A12 Chelmsford to A120 widening scheme

8.15 Statement of Common Ground with Boreham Parish Council

Statement of Common Ground with Boreham Parish Council

Version	Date	Status of Version
P01.1	February 2023	Draft

FIGURE 12.4

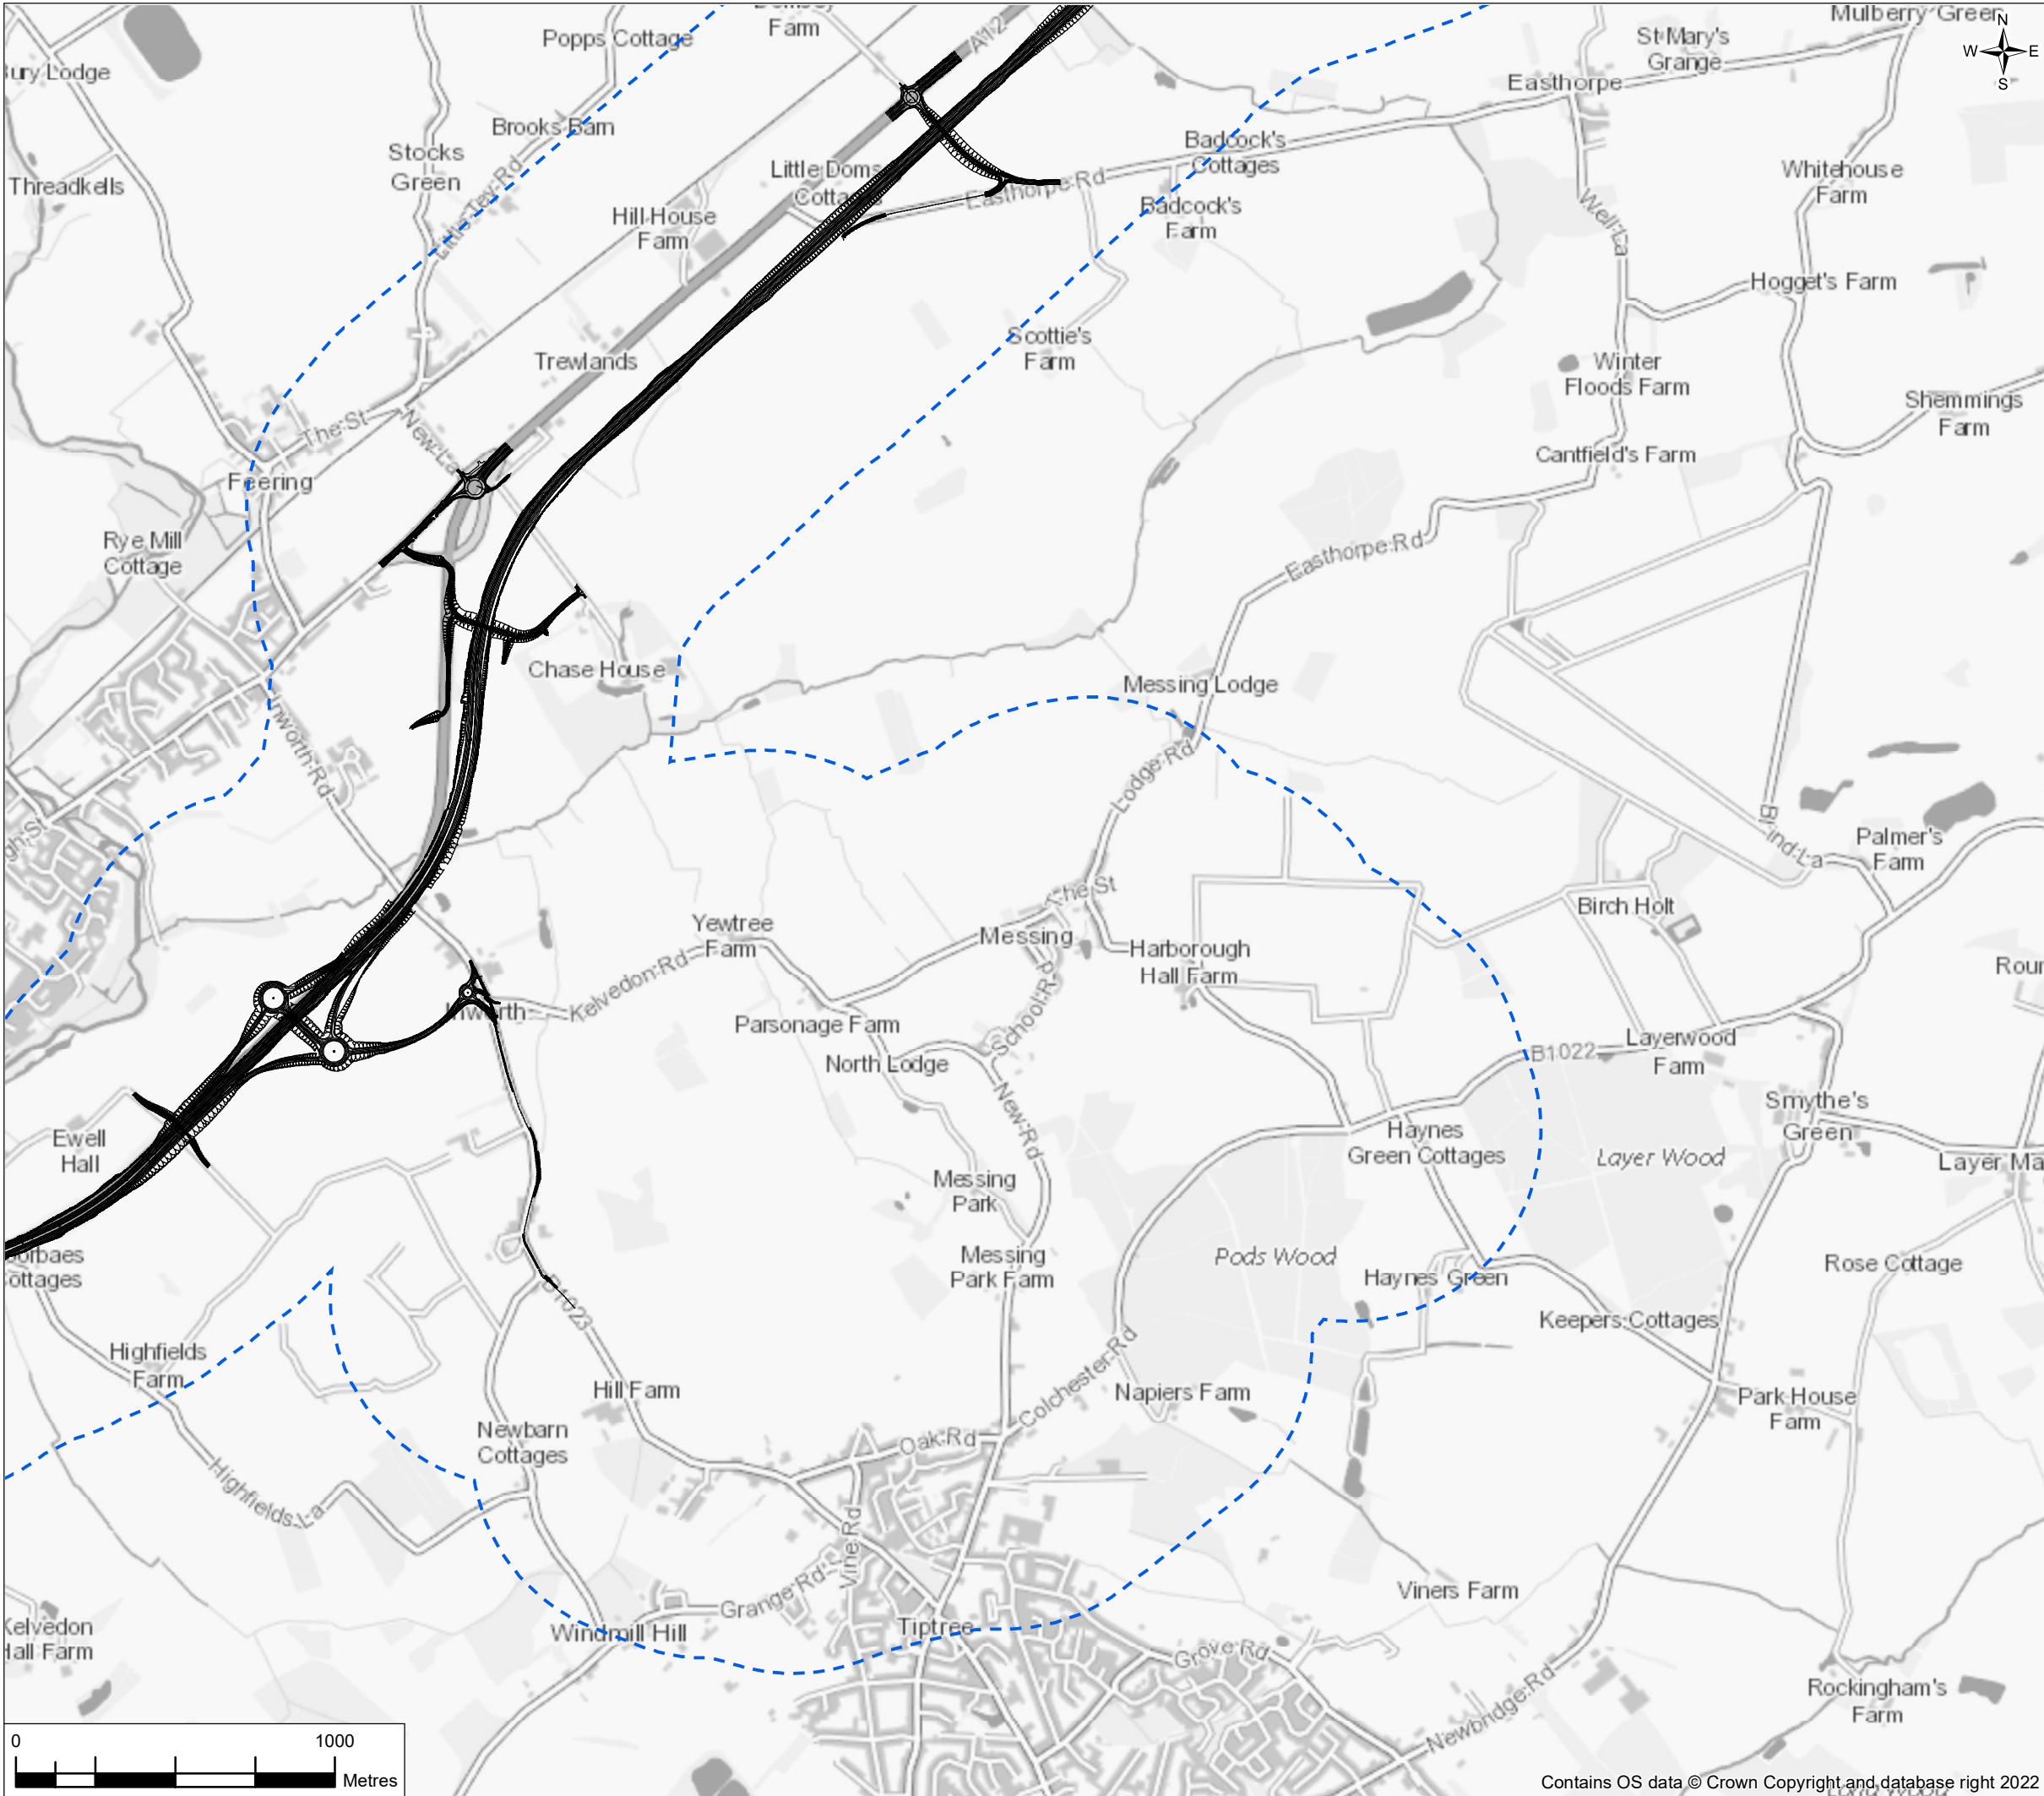
1.2	Noise reducing surfacing		We also ask that the developer reconsiders the decision not to use a noise reducing surface on both carriageways of the A12 as it passes through Boreham. This would benefit houses close to the road by mitigating the additional noise pollution resulting from the A12 widening	<p>Without mitigation, significant adverse effects were identified at 222 dwellings alongside the A12 at Boreham. These significant adverse effects were primarily caused by a predicted increase in traffic speed on the A12, but also an increase in vehicle flow. The increases in noise at dwellings were between 1 and 1.2 dB(A), but with the absolute noise being above the Significant Observed Adverse Effect Level (SOAEL), these were deemed likely significant adverse effects in accordance with Table 3.60 of DMRB LA 111.</p> <p>When significant effects are identified, the first mitigation measures examined are to reduce the noise at source. The path of the noise is then next considered, followed by measures at the receiver. This mitigation hierarchy is described in paragraphs 12.10.1 to 12.10.4 of Chapter 12: Noise and vibration-, of</p>	Under discussion	06/02/2023

Ref	Issue	Doc Reference	Boreham Parish Council Position	National Highways Position	Status	Date
				<p>the Environmental Statement [APP-079].</p> <p>Removing the significant adverse effects through surfacing was therefore considered first. The surface of the A12 alongside Boreham is already a low noise surface, and so following the guidelines in DMRB LA 111 for noise modelling, no benefit in noise terms could be gained through re-surfacing with a conventional low noise surface. Using a surface with better noise reducing properties than a conventional low noise surface was therefore considered. Re-surfacing just one carriageway was first examined in order to retain as much of the relatively new existing surface as possible, and this was found to be sufficient to remove the significant adverse effect at the dwellings, with changes in noise varying between negligible increase and negligible decreases (+/- 0 – 1dB(A)) with the surface with better noise reducing properties than a conventional low noise surface in place on one carriageway. Since this is predicted to</p>

Ref	Issue	Doc Reference	Boreham Parish Council Position	National Highways Position	Status	Date
				<p>reduce the noise level to the level it would be without the scheme, this option was therefore taken forward by the Applicant.</p> <p>The provision of the surface with better noise reducing properties than a conventional low noise surface on both carriageways would deliver minor reductions in noise of between 1.8 and 2 dB(A) at those dwellings alongside the A12. Therefore, the provision of the surface on both carriageways would deliver a minor benefit (which is classed as a noise reduction between 1.0 to 2.9 dB(A)) compared with the identified mitigation which would have delivered negligible changes in noise. With the identified mitigation, all of the identified significant adverse effects would be removed, and this would be the same if both carriageways were resurfaced. The scheme would therefore meet the first aim of paragraph 5.195 within the National Networks -National Policy Statement by avoiding significant adverse impacts on health and quality of life</p>
